Appeal Decision

Appeal Ref: APP/R5510/D/21/3286522

61 Gade Close, Hayes UB3 3PY

- The appeal is made under section 78 of the Town and Country Planning Act 1990 against a refusal to grant planning permission.
 - The appeal is made by Mr H Bakrania against the decision of the Council of the London Borough of Hillingdon.
 - The application Ref 52072/APP/2021/3398, dated 7 September 2021, was refused by notice dated 2 November 2021.
 - The development proposed is a single-storey side extension.
-

Proposed Front Elevation

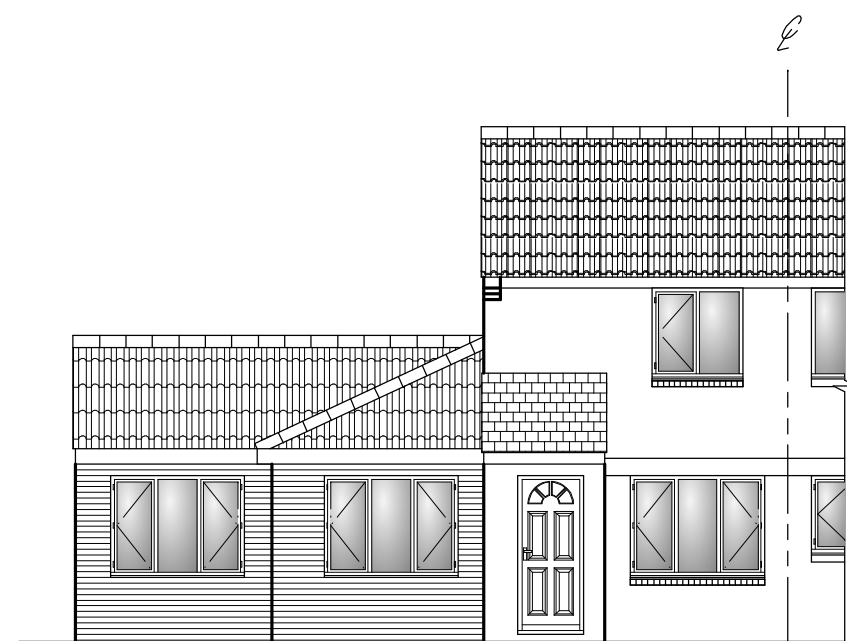
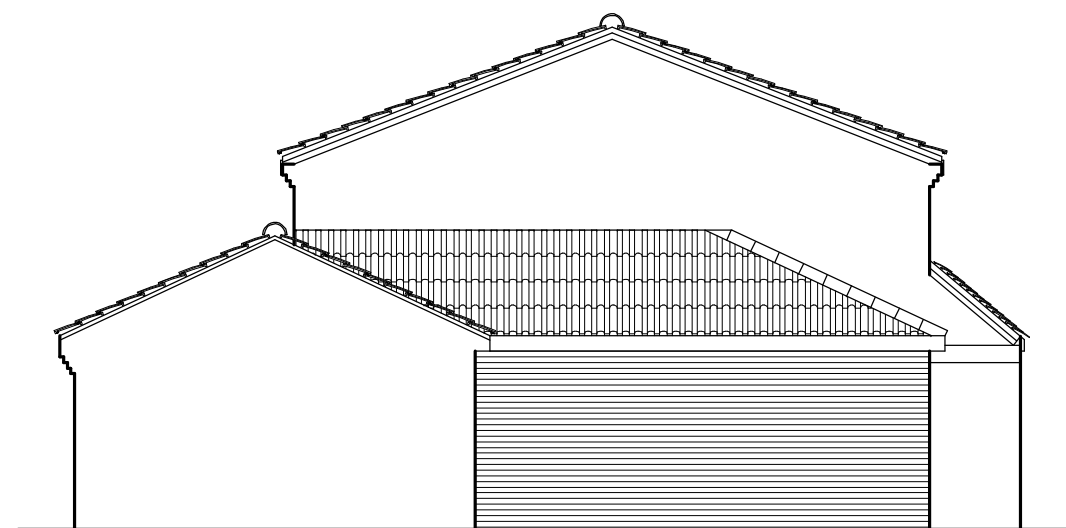
3. The appeal property is a modest two-storey, end-terraced house within a planned estate of similar properties. The proposal seeks the conversion and extension of the attached double garage at the side to form additional living accommodation, which has been labelled on the plans as a 'granny annexe'.
4. The design and scale of the extension including complementary materials and fenestration would harmonise with the host property. The limited width, single-storey height, and the set back behind the front elevation, would also render the extension subordinate to the host property and unobtrusive in the street scene. Consequently, the extension would not cause harm to the character or appearance of the host property or wider surrounding area.
5. I therefore conclude that the proposal complies with Policy BE1 of the Hillingdon Local Plan: Part One - Strategic Policies (2012), and Policies
